Your Ref: Mr Bolland
Our Ref: BN/99/21/DOC

Town & Country Planning Act 1990 (as amended)
Town and Country Planning (Development Management Procedure) (England) Order 2015
Approval of details reserved by condition imposed under BN/62/20/HH relating to condition 3-surface water drainage.
Barnham Court Church Lane Barnham PO22 0BP

Arun District Council have decided to **REFUSE details reserved by condition for the following reasons:**
Drainage have been consulted on the application and visited the site, noting that some works have already taken place on the site.

DRAWN BY	CHECKED BY	DESIGNED BY
PF	JL	JL
SCALE @ A1	© DATE	STATUS
1:100	July 2021	Planning
JOB NO.	DRAWING NO.	REVISION
31789	EX.01	P2

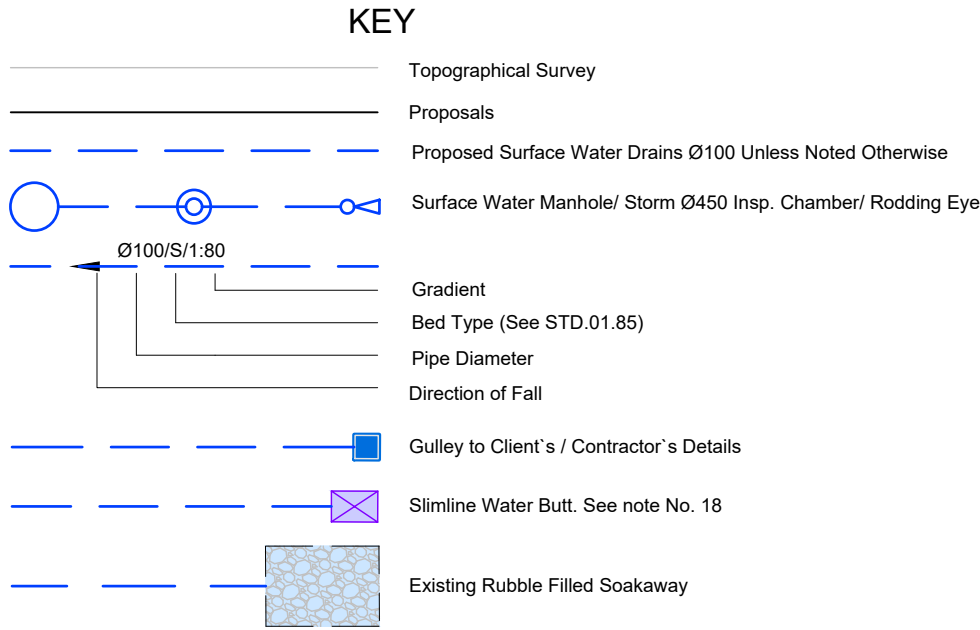
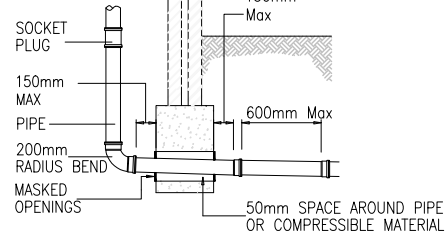
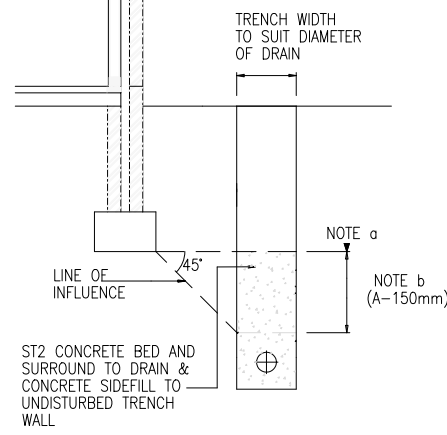
1. Confirmation is required as to the extent of the drainage system that has been constructed. Of that

constructed, the engineers will need to produce an as constructed drawing. From a site inspection, it would appear that the overflow pipe has not yet been connected to the ditch and has been laid up to the existing trackside hedgerow. Please note that remedial works may be required but this is dependent on the other matters below being resolved/considered.

2. There is some doubt as to whether the pipe discussed above (between boundary wall and hedgerow) has been laid to the proposed gradient and certainly its bedding will need to consider item 3 below.

3. The entire length of the outfall pipe between the gully and the ditch will require concrete bed and surround due to minimal cover and the risk of root intrusion, etc.

4. Land drainage consent is required for the connection to the ditch and needs to be applied for/approved prior to discharge of this planning condition. The connection to the ditch must not be made until such time

5. Has the proximity of the soakaway to existing and proposed buildings been considered in terms of the possible effect on foundations? This is critical to the whole scheme.

6. Gutter leaf guards are required to reduce the risk of leaf matter blocking the orifices.

7. Clearly indicate manhole and gully cover levels.

8. Show all gully invert levels.

9. Specify all inlets/outlet invert levels to/from channel drains.

10. Indicate invert levels of all pipes connecting into the soakaway including the outlet.

11. Indicate gradients of all pipes and channels.

12. Gullies must have sufficient traps for silt collection or else additional silt traps will be required in the form of catchpit manholes.

13. Introduce a crate layer to the soakaway to provide a means to formally connect pipework into the structure.

14. The pipework arrangement within the manhole in the SE corner is acute and needs reconfiguring.

15. Full construction details are required of all drainage elements.

16. Provide more details of the Freeflush water butts ie. brochure/construction details. It also needs to be shown how the orifice connects to the outlet pipe.
